HIGHWAYS DEVELOPMENT CONTROL
CONSULTATION RESPONSE

PLANNING CASE OFFICER	Laura Bennett
HIGHWAYS OFFICER	Jamie Turner
PLANNING APPLICATION REF.	2024/0122
LOCATION	Land north of Hemingfield Road, Hemingfield, Barnsley
DESCRIPTION	Outline planning application for demolition of existing structures and erection of residential dwellings with associated infrastructure and open space. All matters reserved apart from access into the site
ASSOCIATED PRE-APPLICATION	2023/ENQ/00437

Drawing No: 23/160/ACC/001

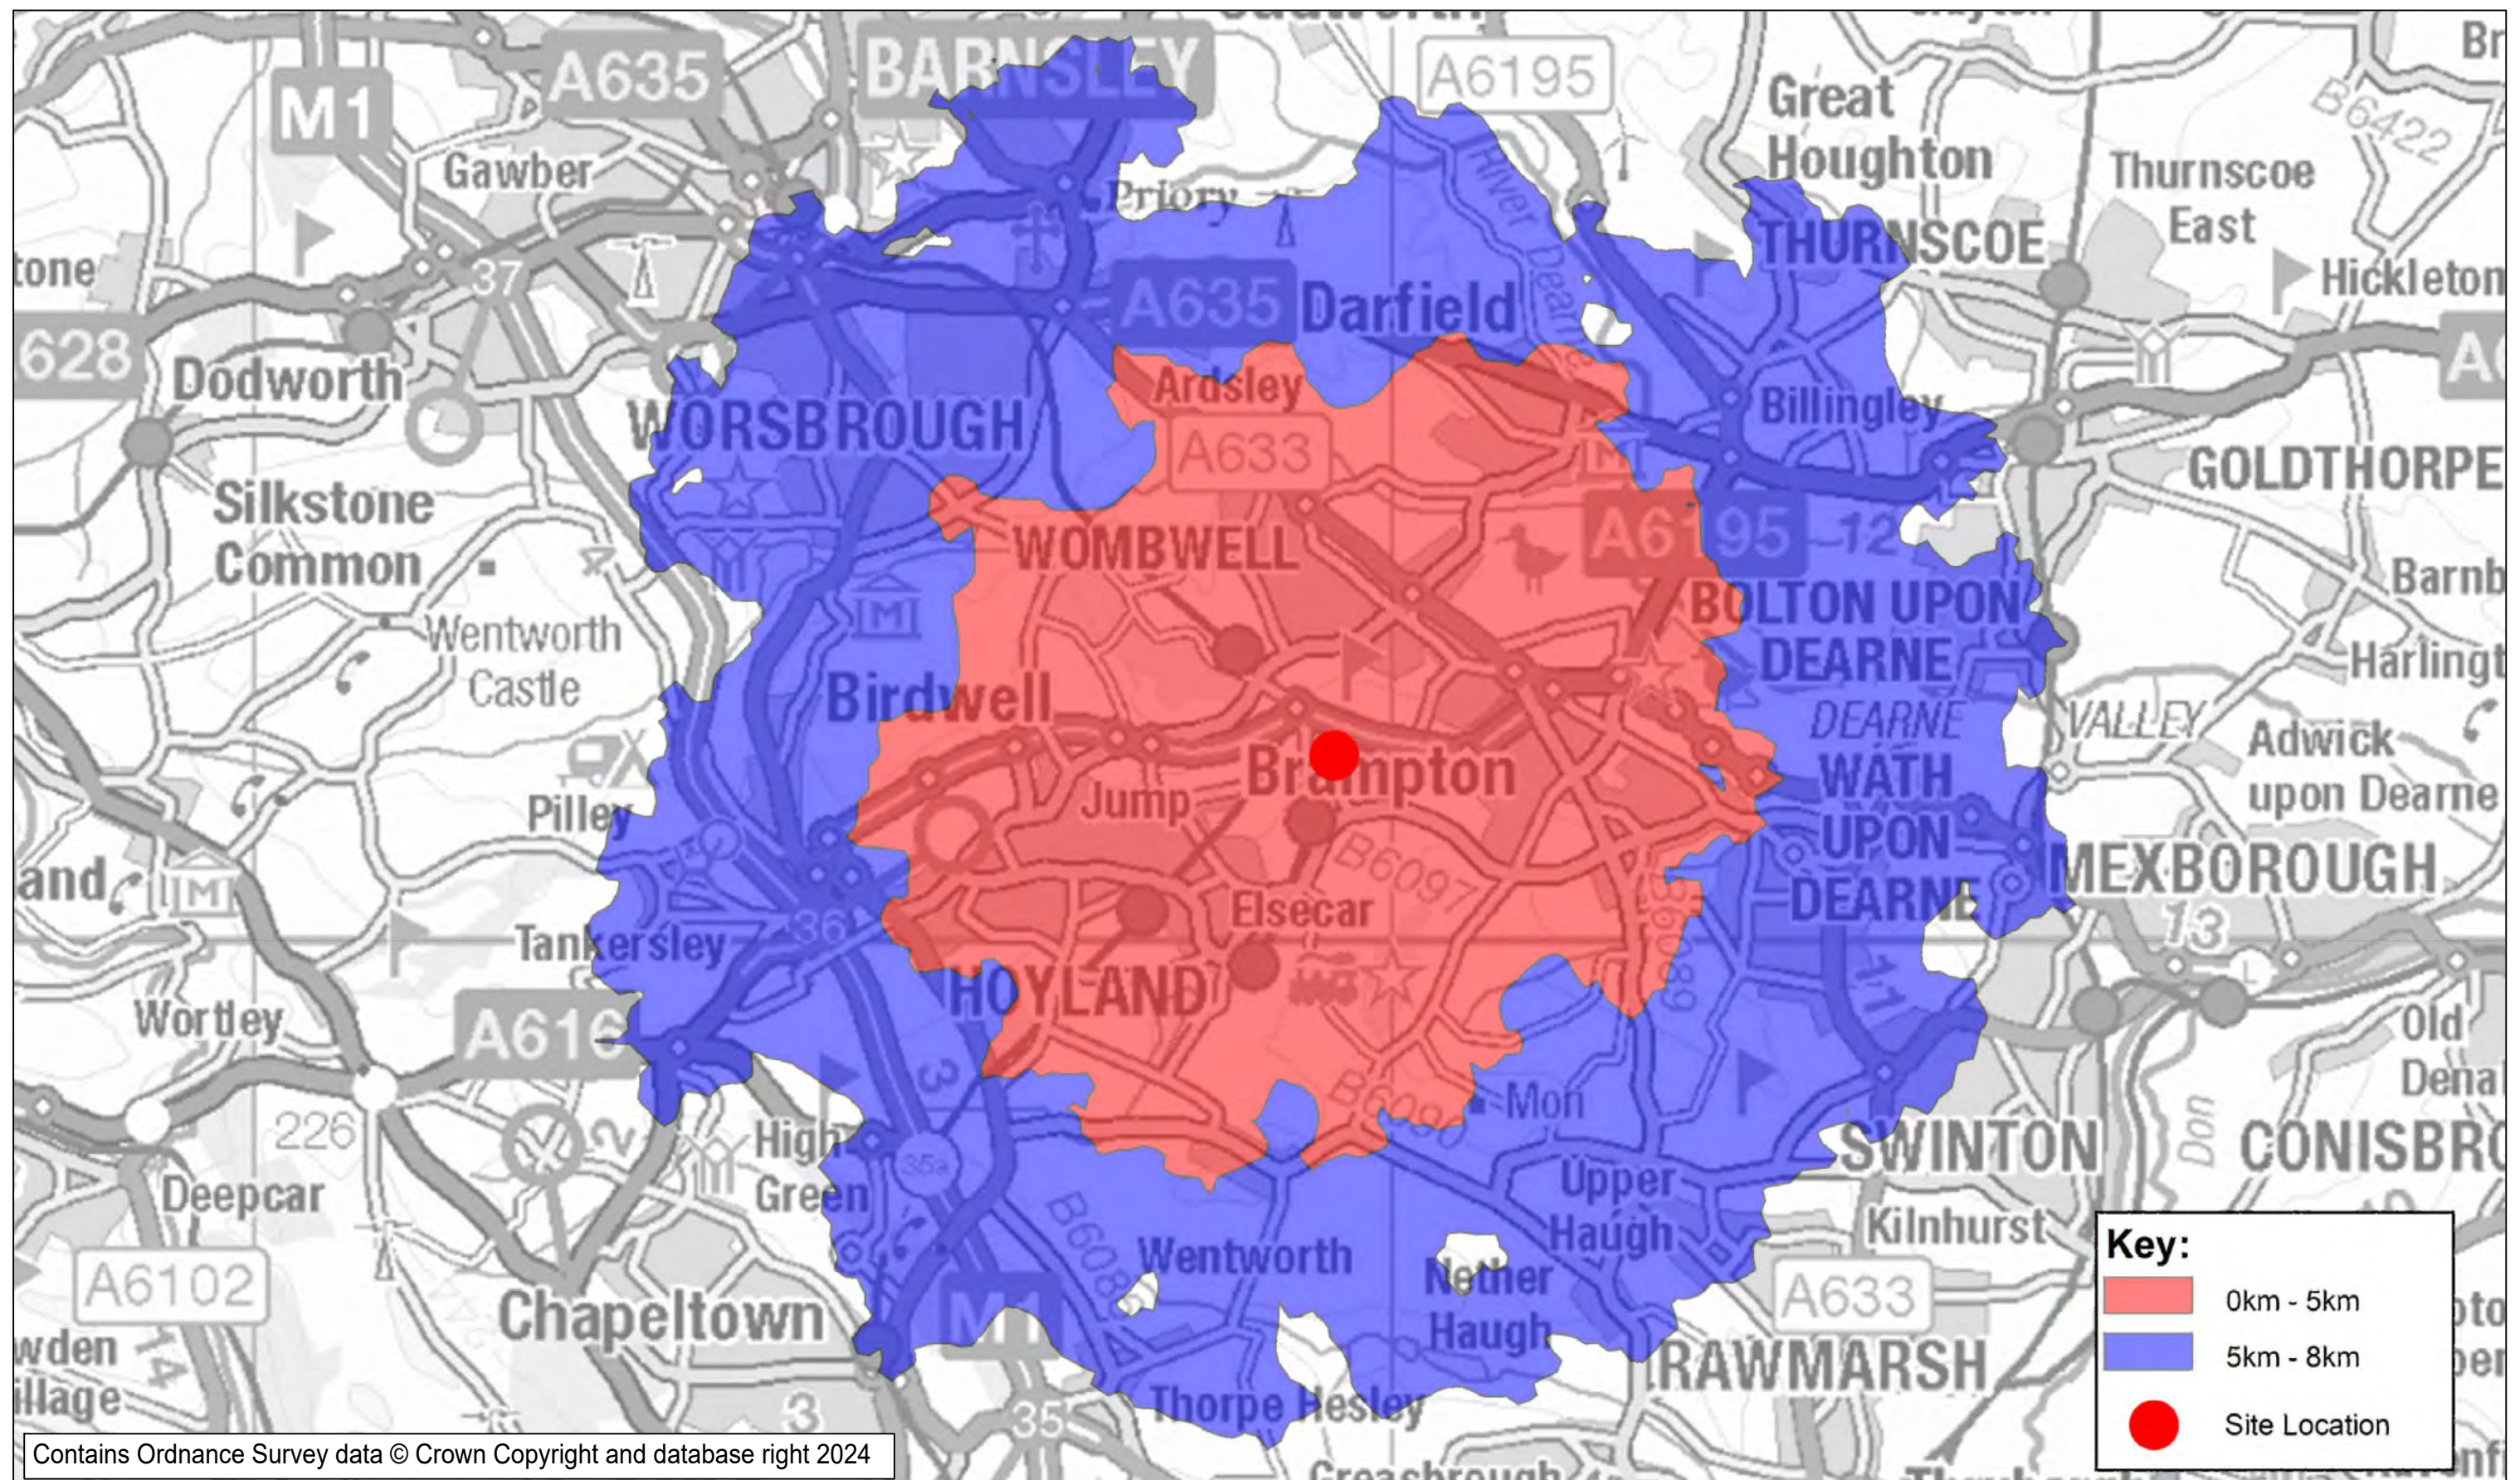
Although the application is outline except for access, Highways DC officers would wish to be provided with a detailed design of the proposed access to ensure it can be constructed adequately up to and including the first spur off within the proposed estate.

Given the proliferation of sustainable transport routes within and adjacent to the site, Highways DC would ask that a 3.0m shared-use path is provided rather than the 2.0m footways shown on the submitted plan. Consideration should also be given to widening the carriageway at the access point, this is firstly due to the number of dwellings it would serve and also to allow the maintenance of two-way flow of traffic should work be required to be carried out at the junction.

Independent Stage 1/2 safety audits should be carried out to ensure safe design and the results submitted for consideration by the Council's Traffic Department.

Drawing No: 23/160/ACC/002

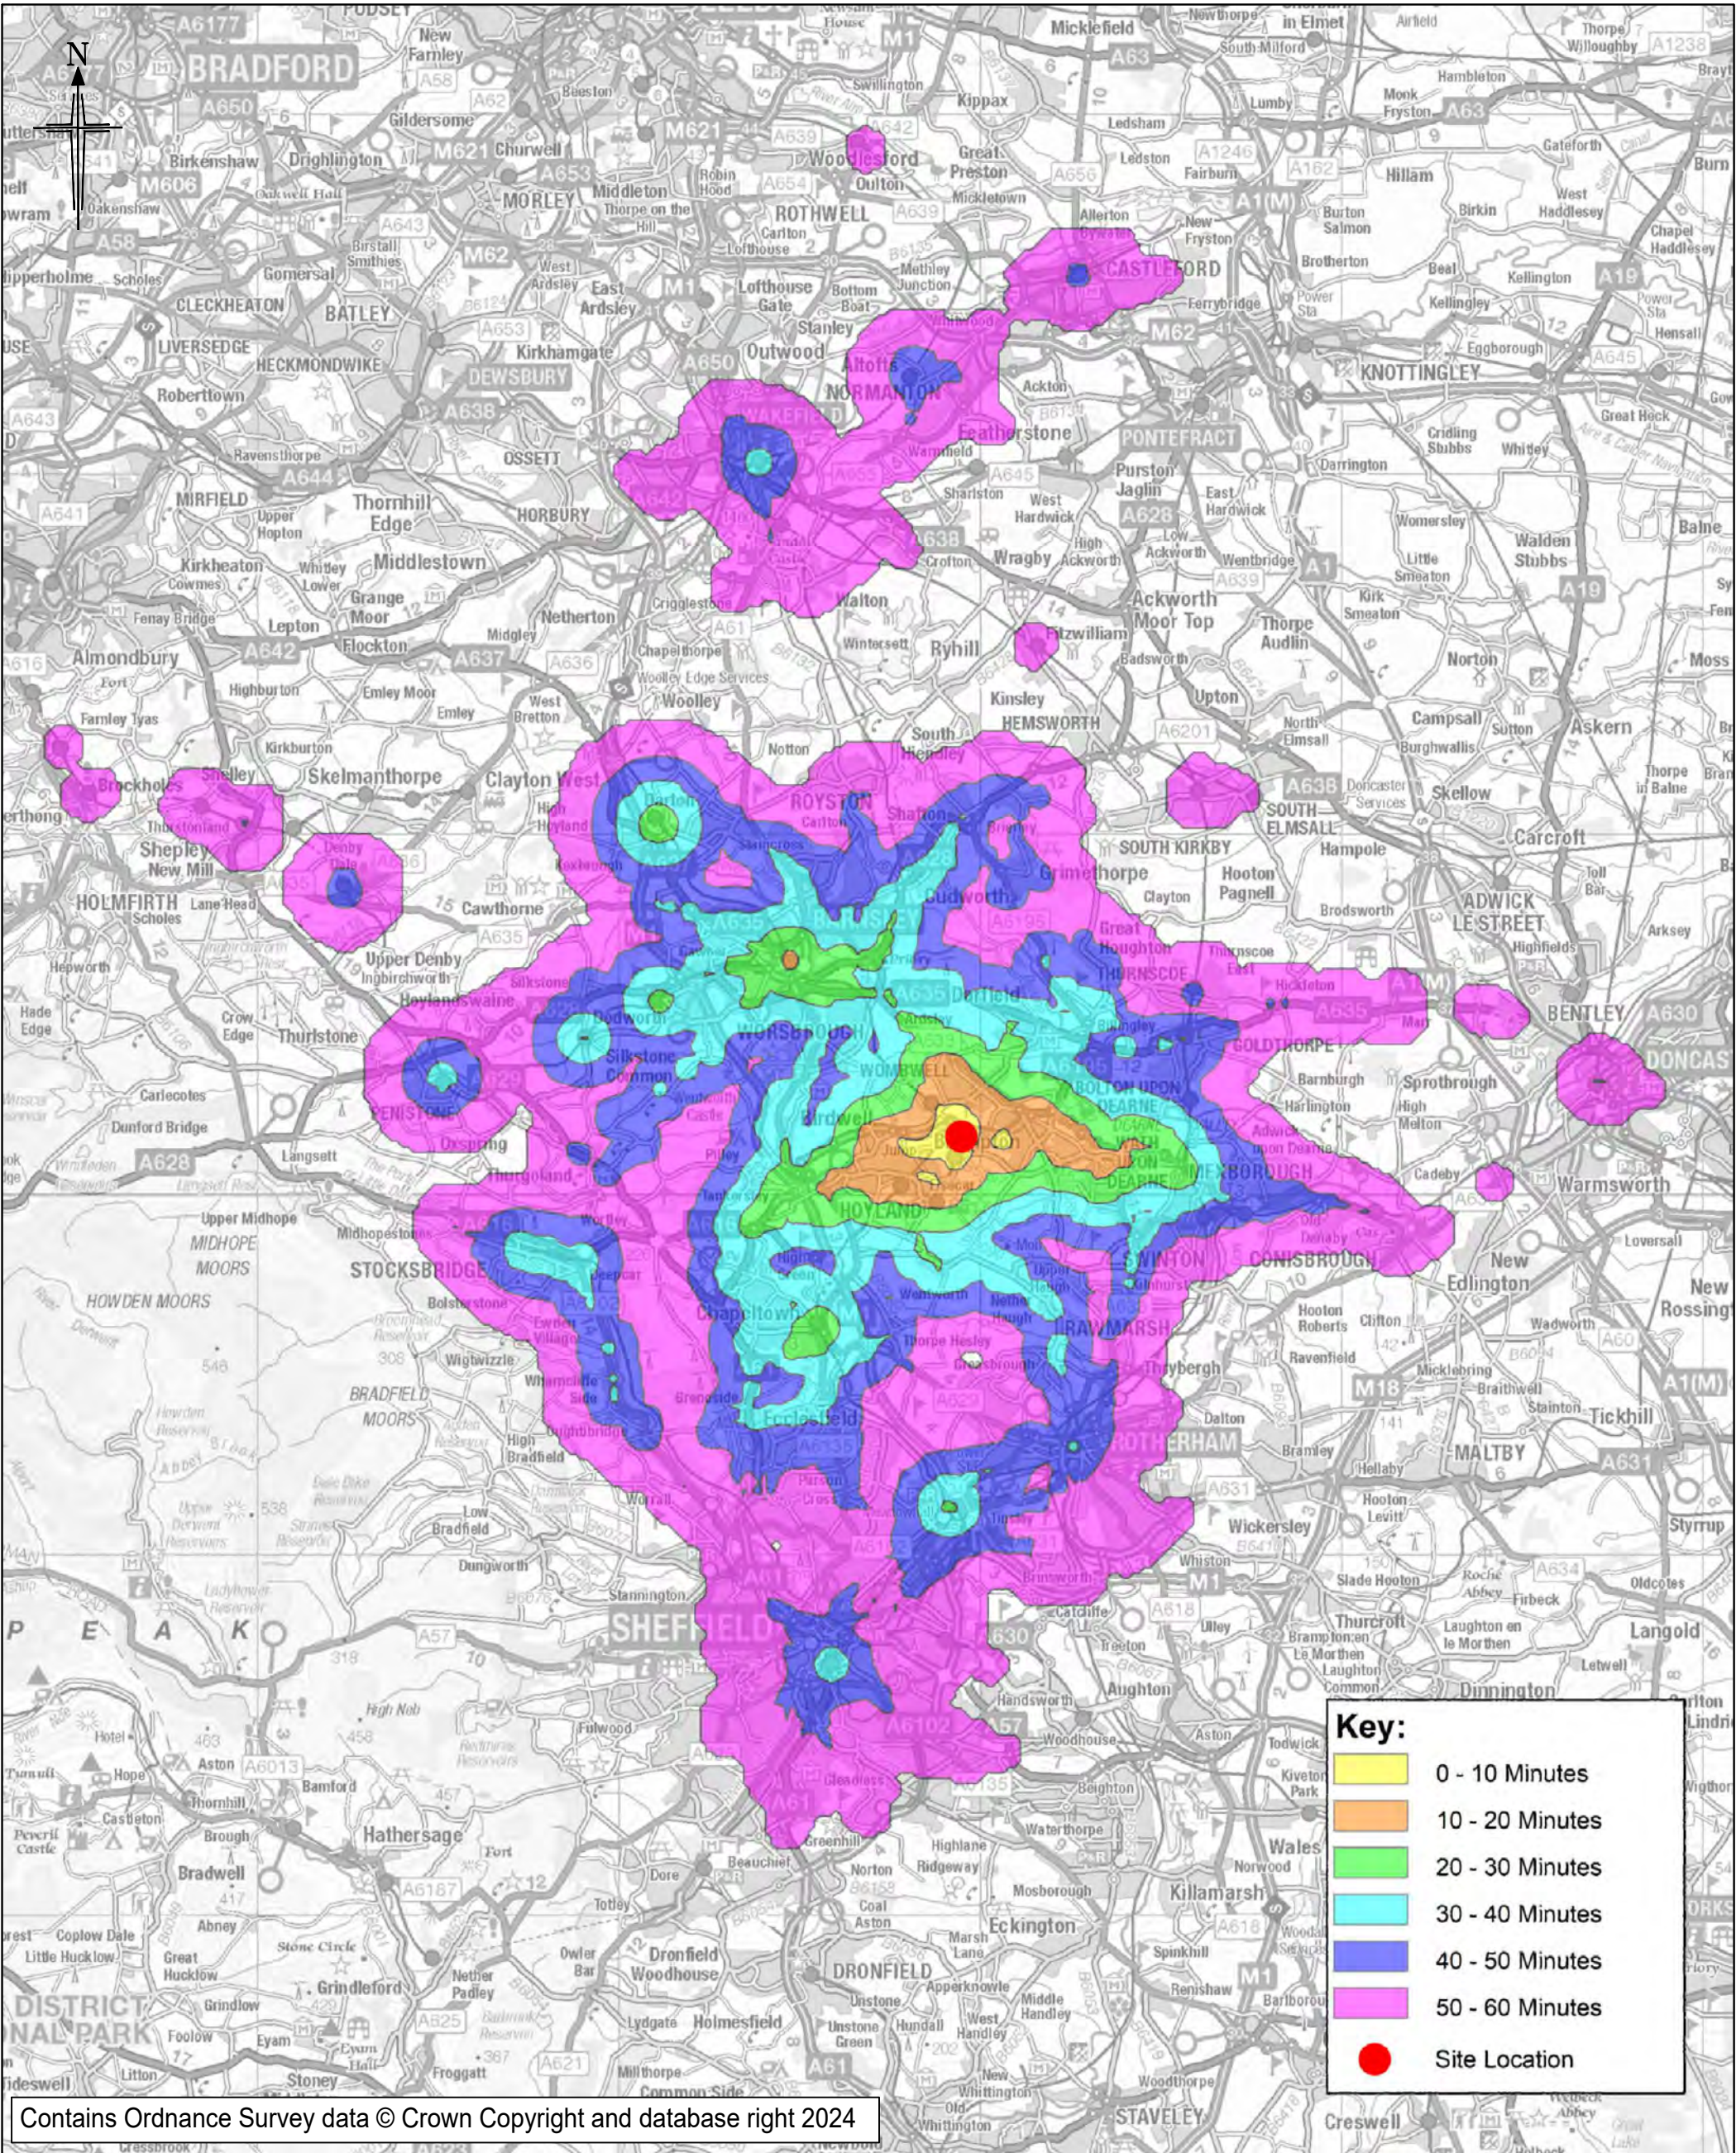
As mentioned in the pre-application response 2023/ENQ/00437, the refuse vehicle that requires tracking is as follows: Length 11 metres, width 2.75 metres, height 4.5 metres, weight 26 tonnes, turning circle needed 15.25 metres. A 0.5m gap from the edge of the carriageway or other obstruction should be maintained at all times when tracking vehicles. The tracking should therefore be updated.
